Our Case Number: ABP-314597-22

Re: BusConnects Galway Cross-City Link Scheme.  
University Road to Dublin Road, Galway City.

RE: Planning Application REF: HA61.314597– University Road to Dublin Road, Galway City

I am making this observation in relation to the request for planning permission for the proposed cross-city link scheme by Galway City Council (Ref: HA61.314597).

Role	Transport Infrastructure
Suitability	Planning
Arup Job No	253352-00
Name	BCG-GA-00-02
Rev	PL01

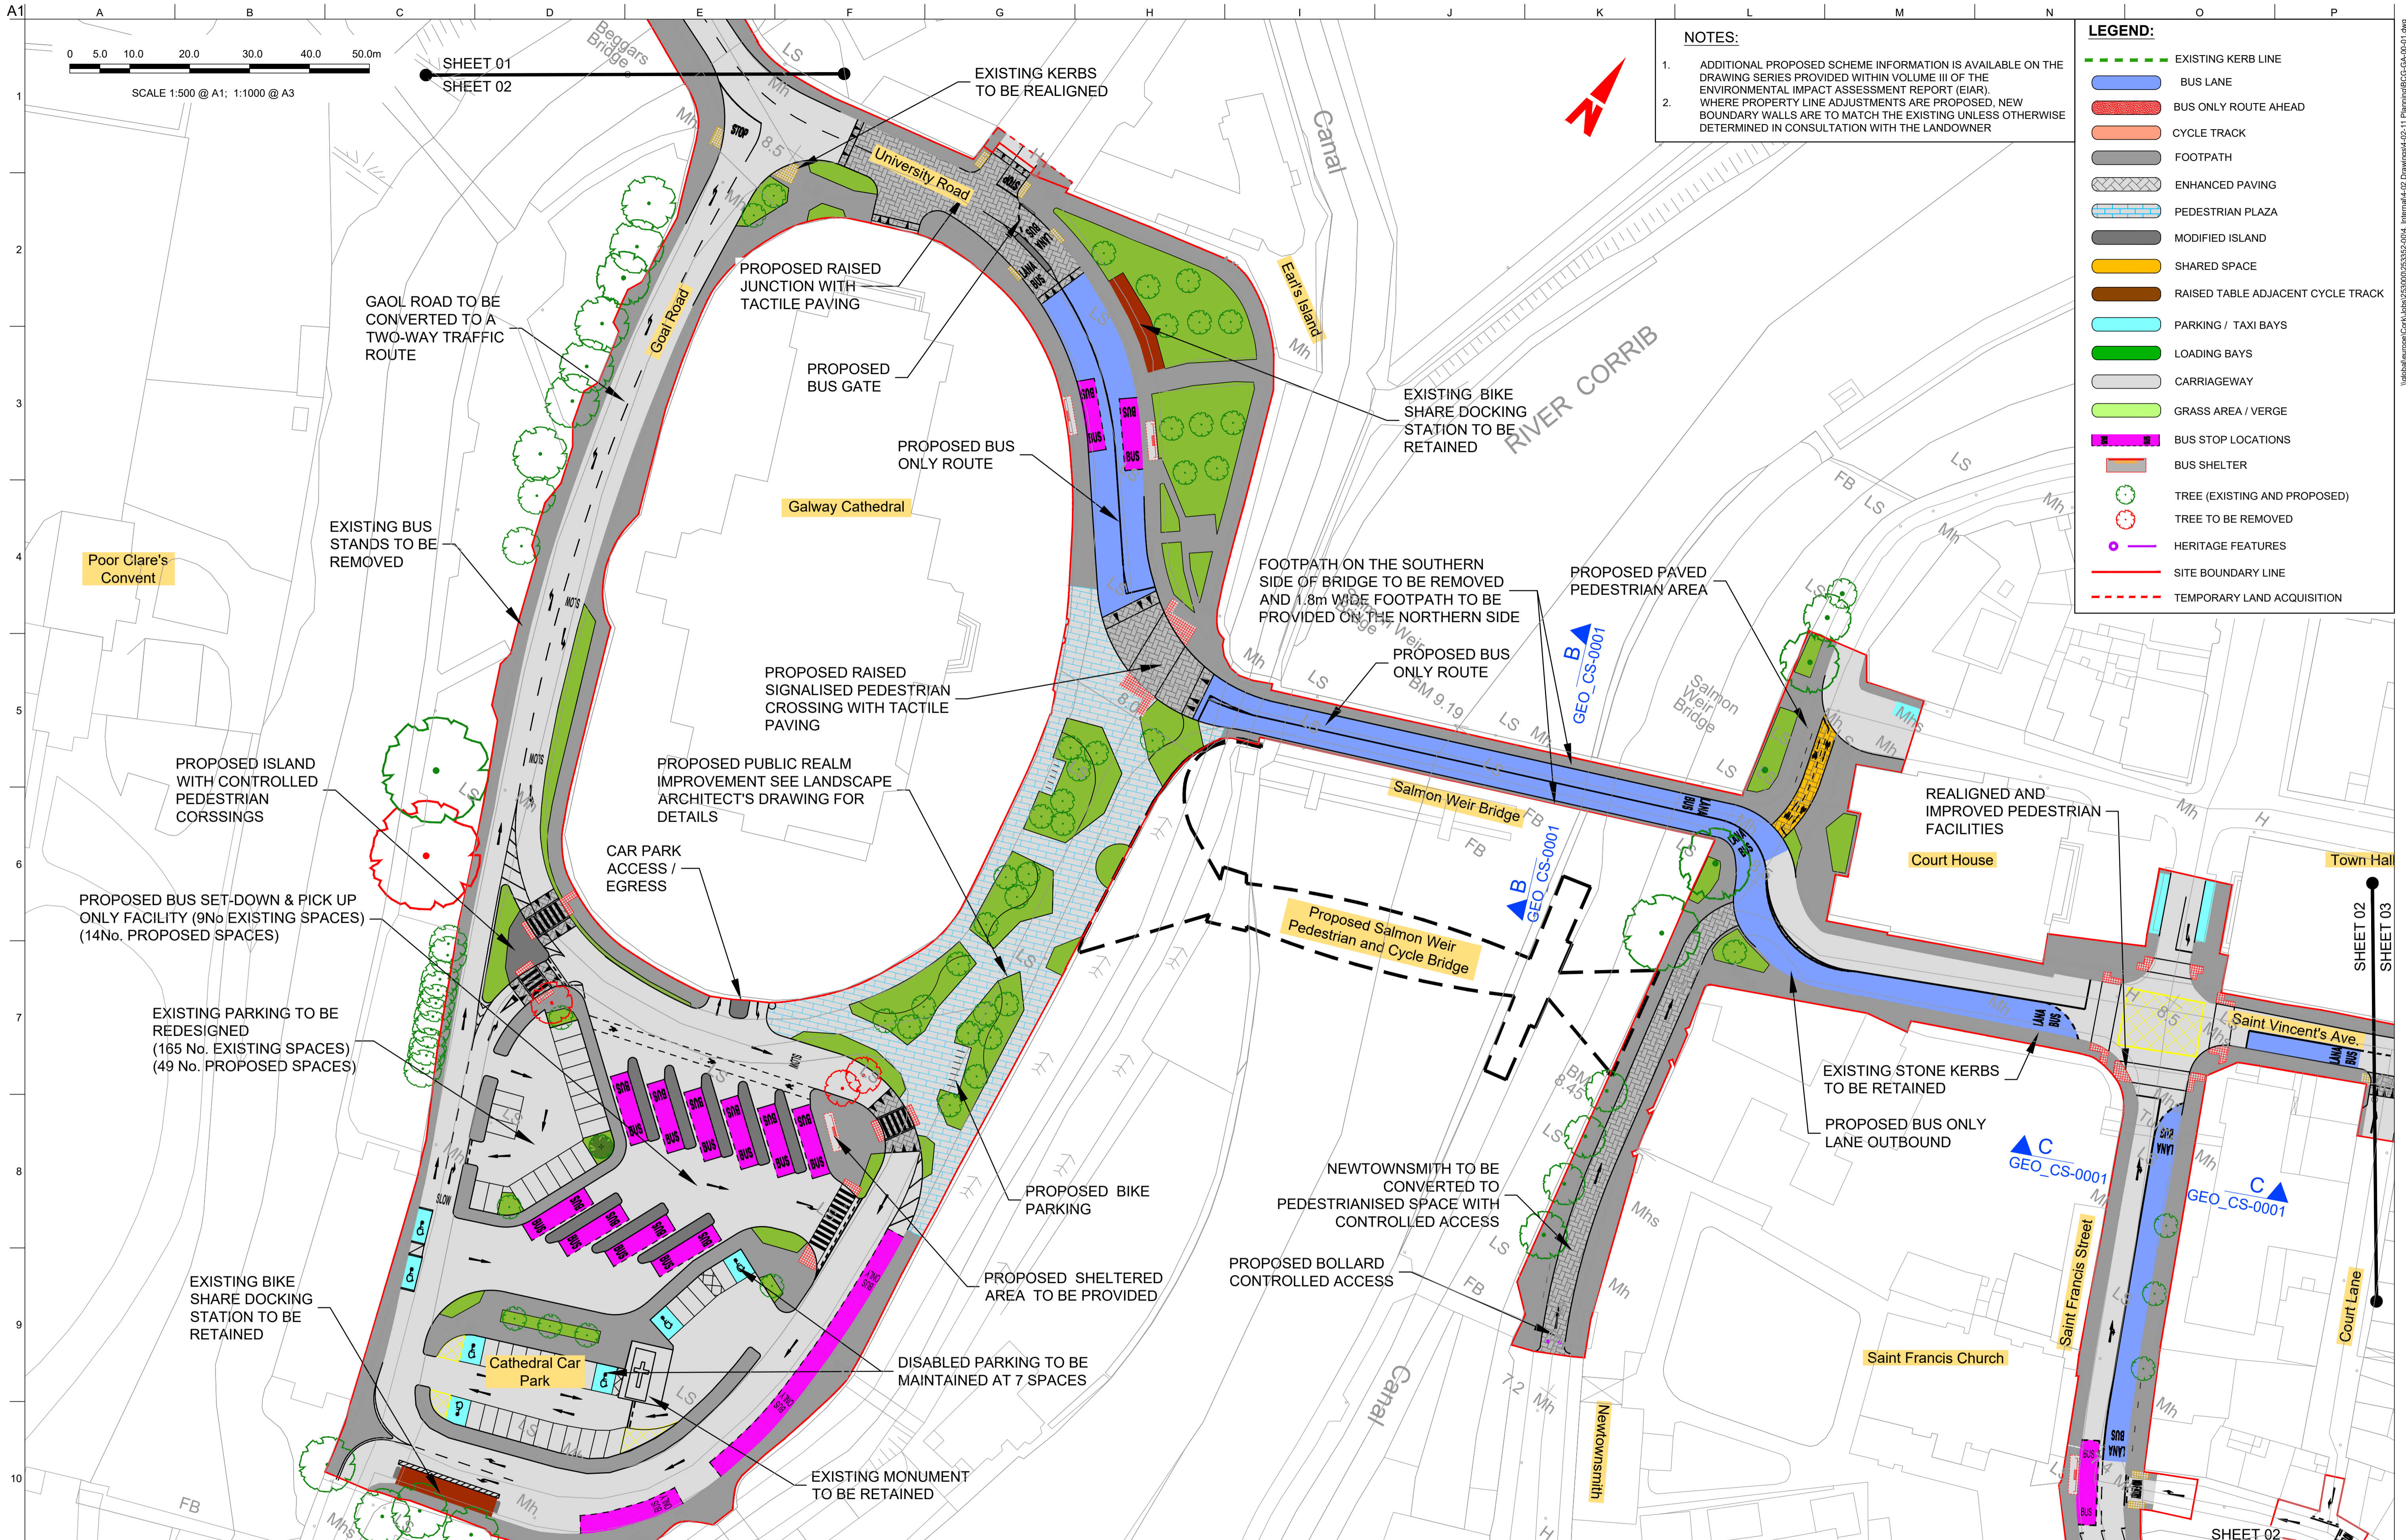
Drawing No. BCG-GA-00-02 General Arrangement sheet 2 of 13 shows the proposed revised traffic layout at the Galway Cathedral. This proposal includes a revision to the traffic flow on Goal Road. Cyclists wishing to cycle in the direction of Nun’s Island do not have a direct route.

Request: that a contra-flow or segregated cycle path to connect Goal Road to Nun's Island as indicated by the blue arrow be included.
